Ref No: DA220-07-2002-I MOD 5

Matt Wentzel
Cargill Beef Australia
PO Box 166
WAGGA WAGGA NSW 2650

RE: Cargill Irrigation Proposal

Figure 5: Cargill's proposed pump station, irrigation pipe and interception trench

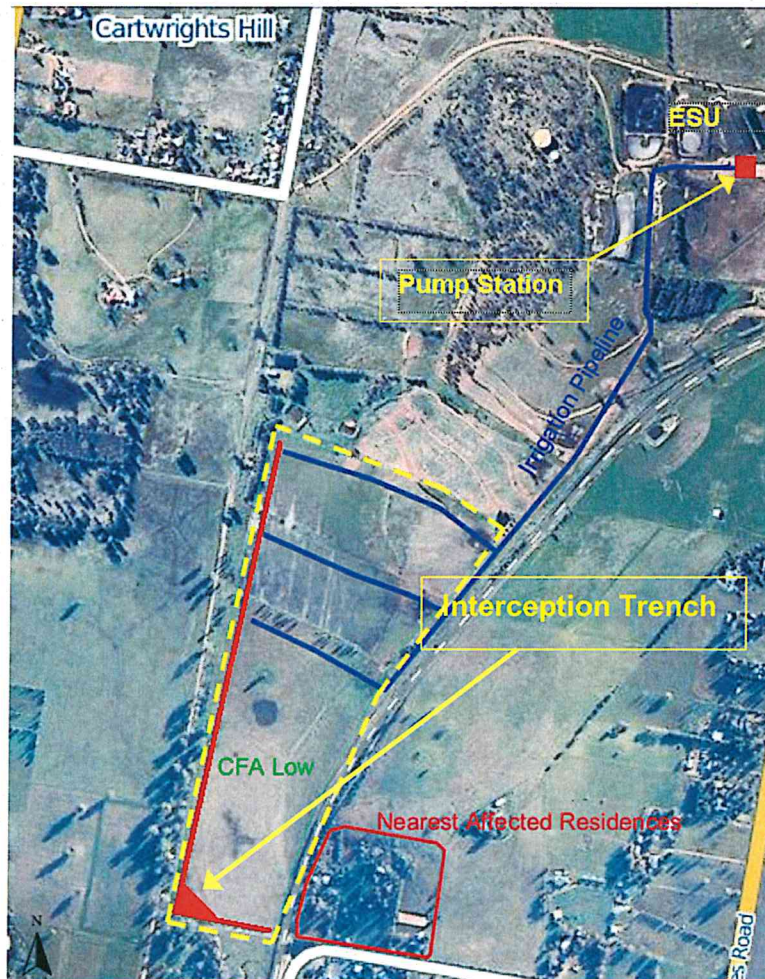
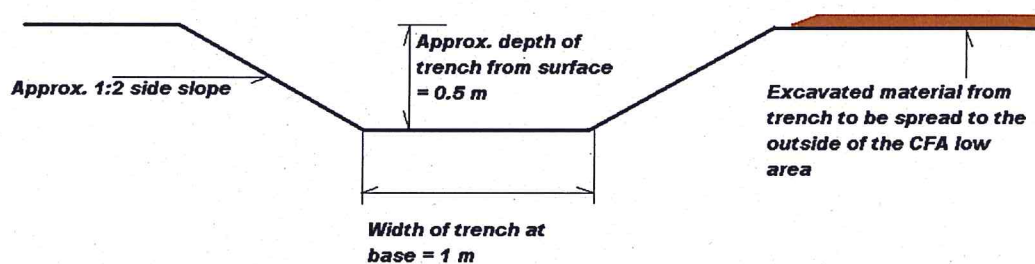
1. The replacement of the berm with an interception trench along the southern and western edges of CFA low area would be sufficient to resolve Council concerns regarding the impact of the proposed development on flood waters and the capacity of the flood plain.
2. The implementation of the interception trench is adequate to satisfy the matters raised previously by Council in relation to water contamination.
